23 November 2010

**Major Project 10_0107 – Residential Development – Buildings 1, 2 & 3
61 Mobbs Lane - Epping - Channel 7 Site (Epping Park)**

02 FIRST FLOOR PLAN

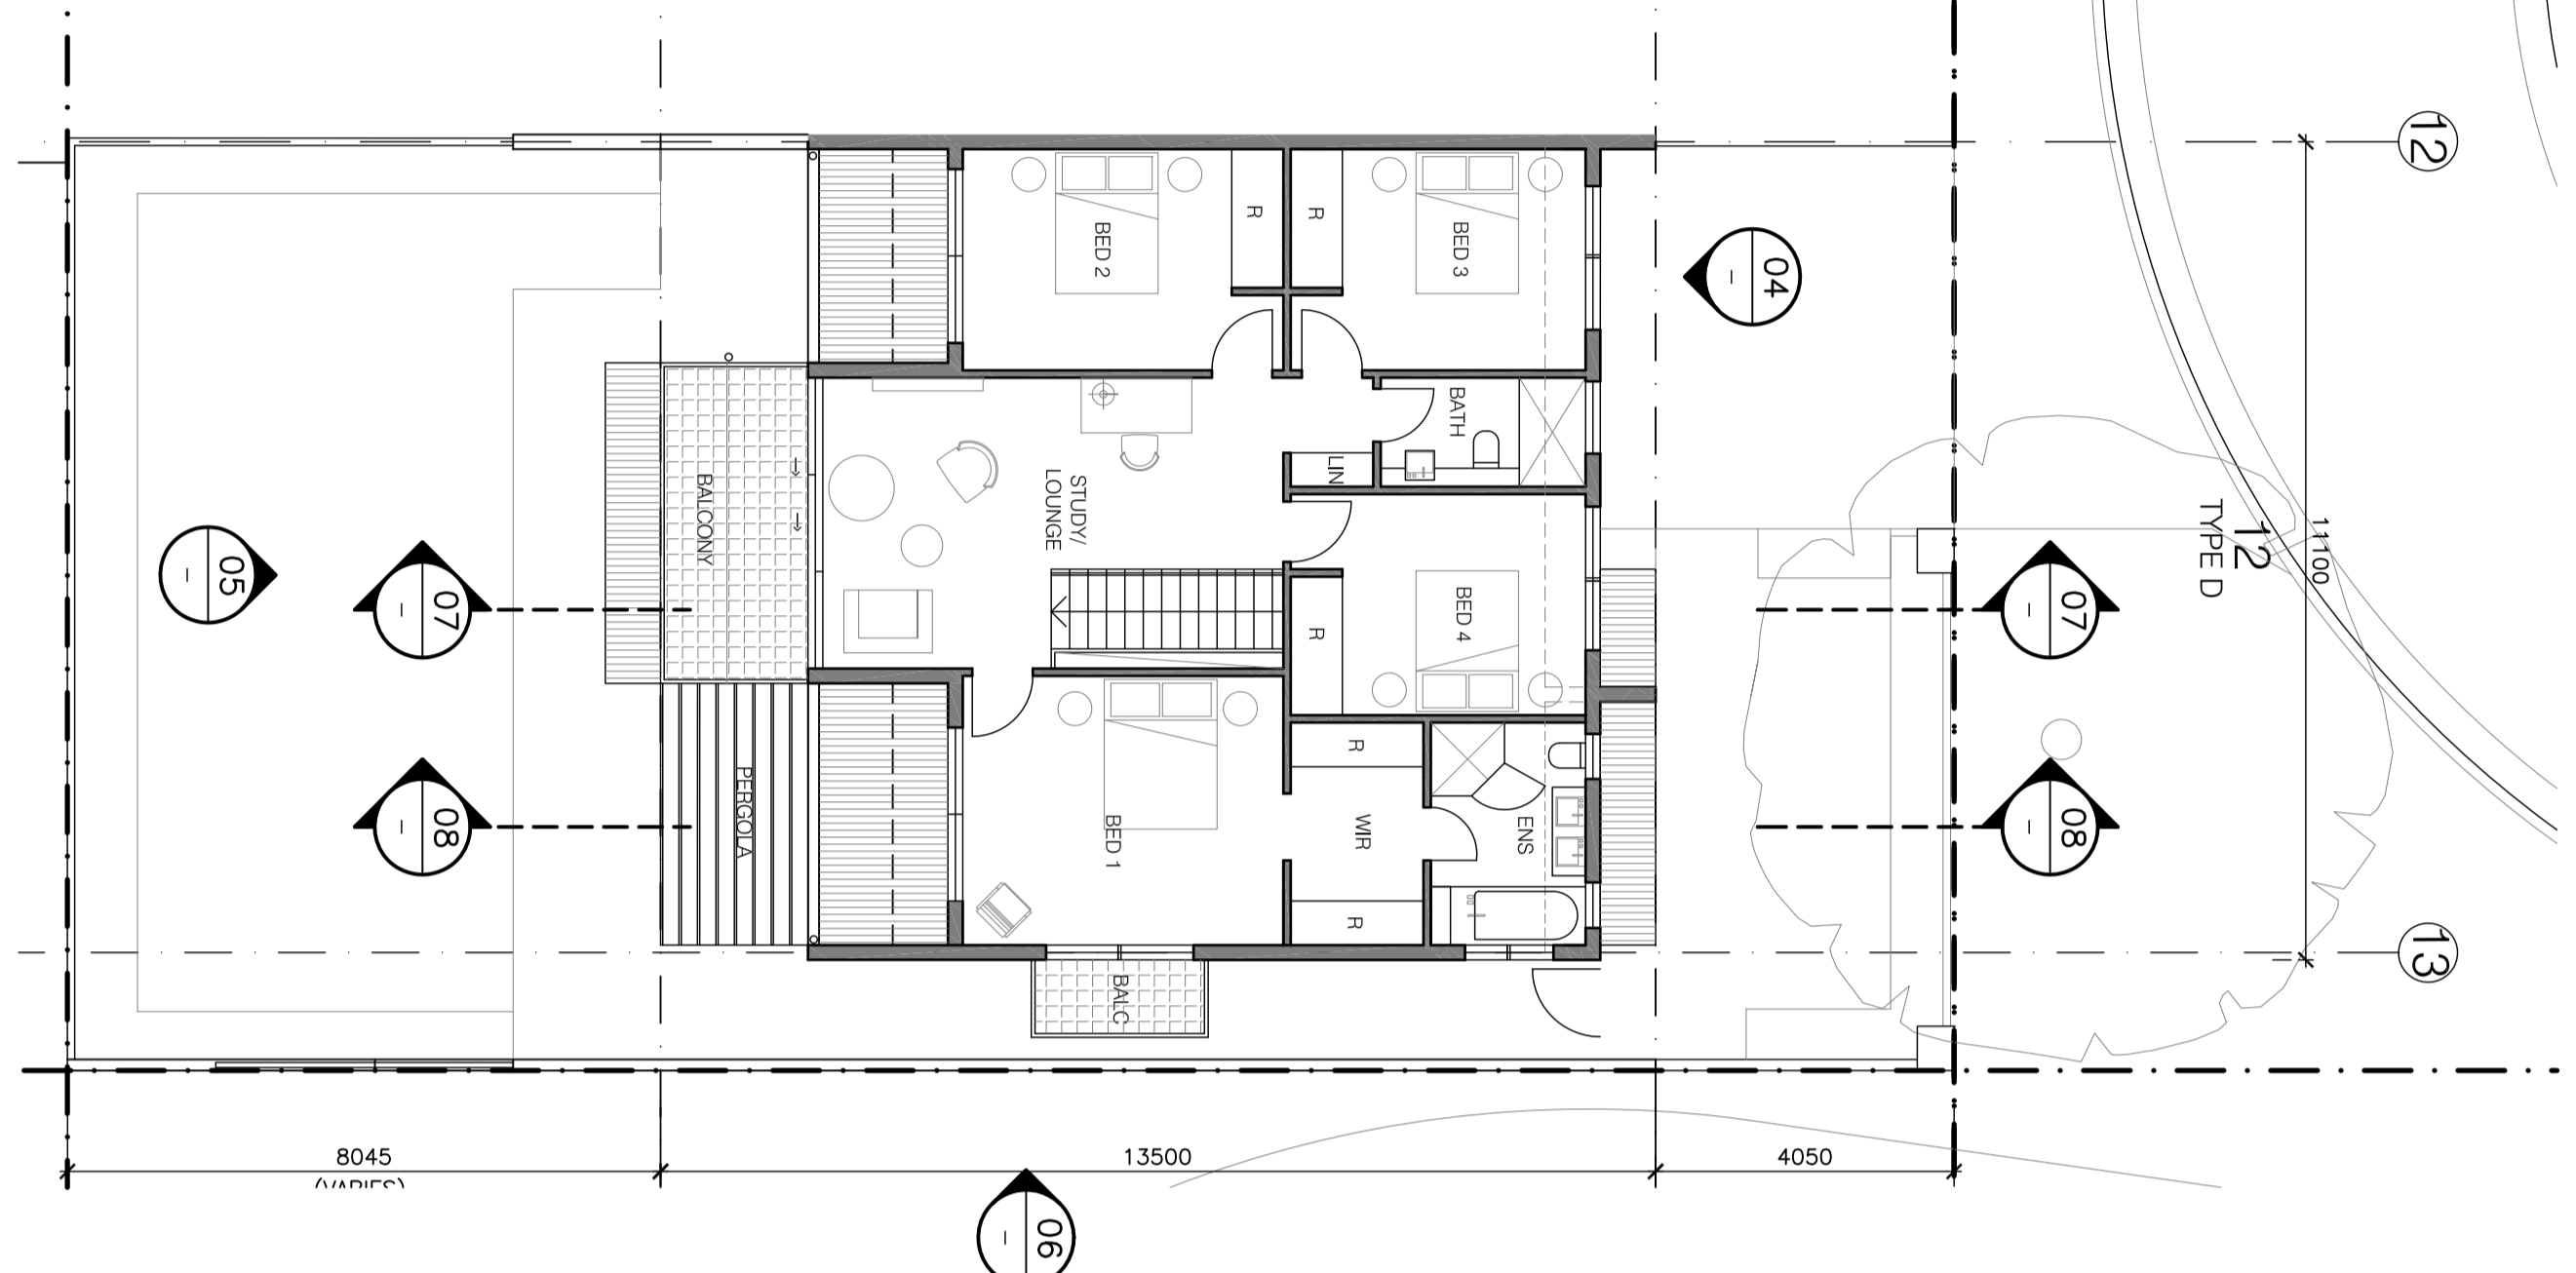
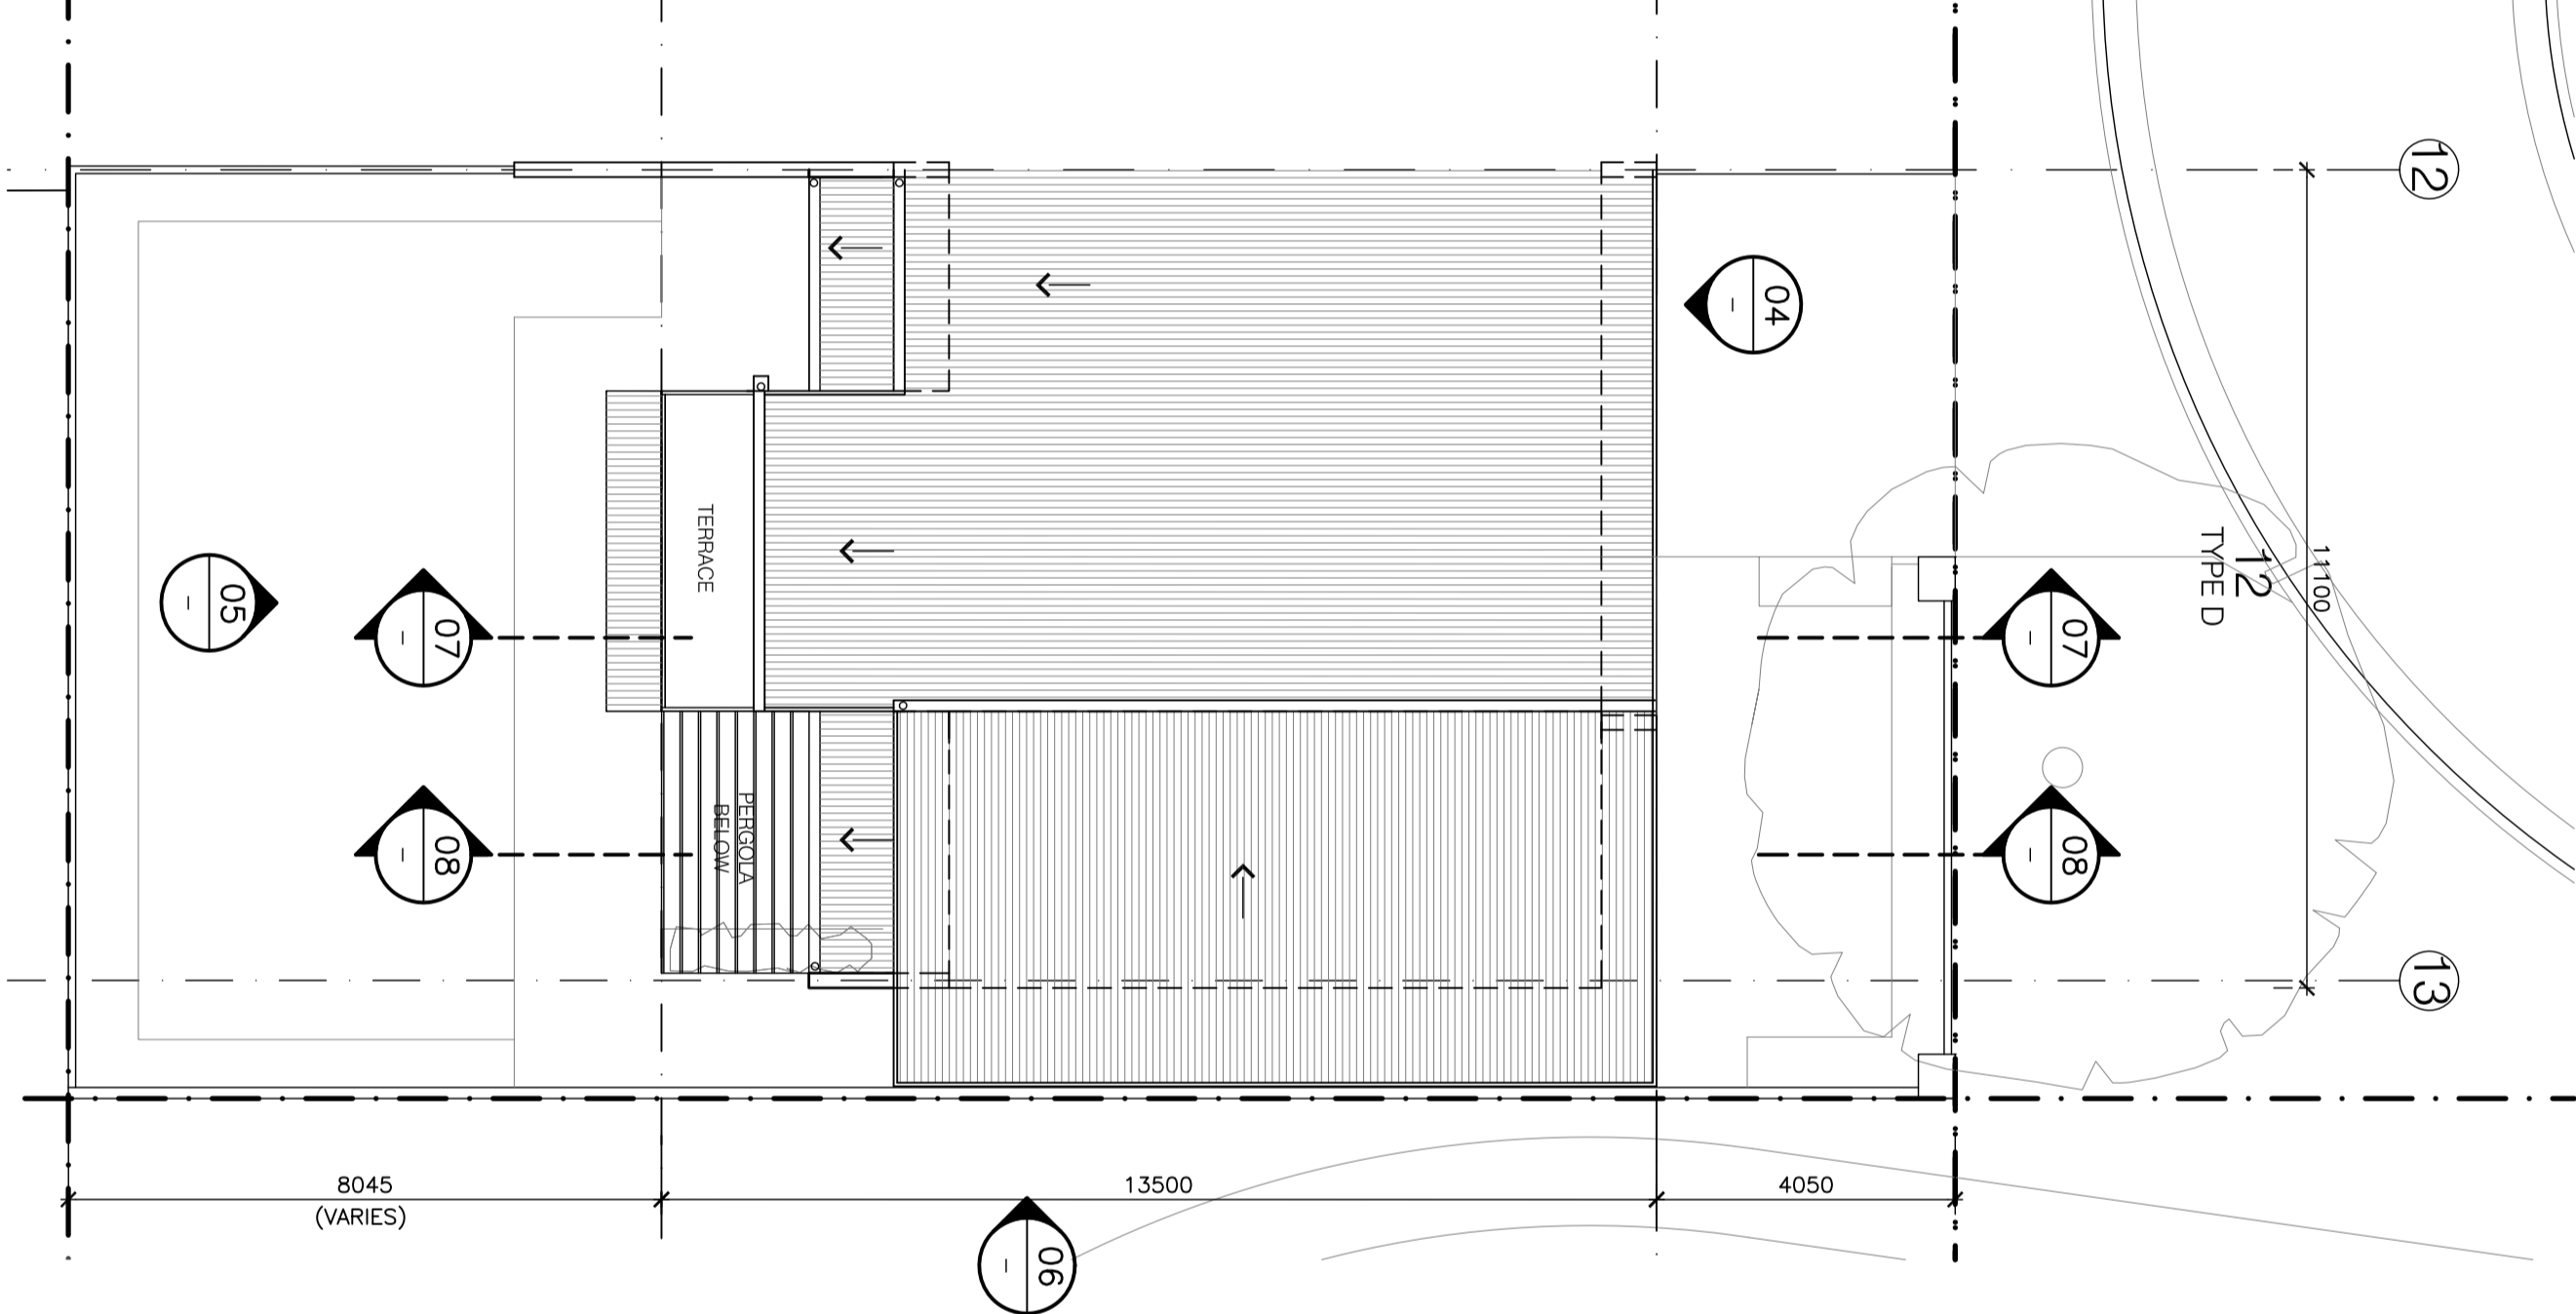
The reproduced Concept Plan is of poor quality and it is unclear if a 6.7m or 8.7m is required to the eastern property boundary adjoining the rear yards of the detached dwellings. The proposal provides a varying rear setback to building 3 of approximately 8m. Clarification is sought about the setback required under the approved Concept Plan to the eastern boundary. If the setback is 8.7m, the proposal should be amended to comply with this requirement to protect the amenity of the adjoining properties, provide greater private open space and landscaping.

The height controls for building 3 within the approved Concept Plan indicates a transition from 2 storeys to single storey towards the eastern site boundary. The application proposes a largely 2 storey building form with a limited single storey component. The proposal also includes roof elements that extend up to 2.75m above the upper level ceiling height for architectural articulation of the long linear building form. This appears excessive and unnecessary.
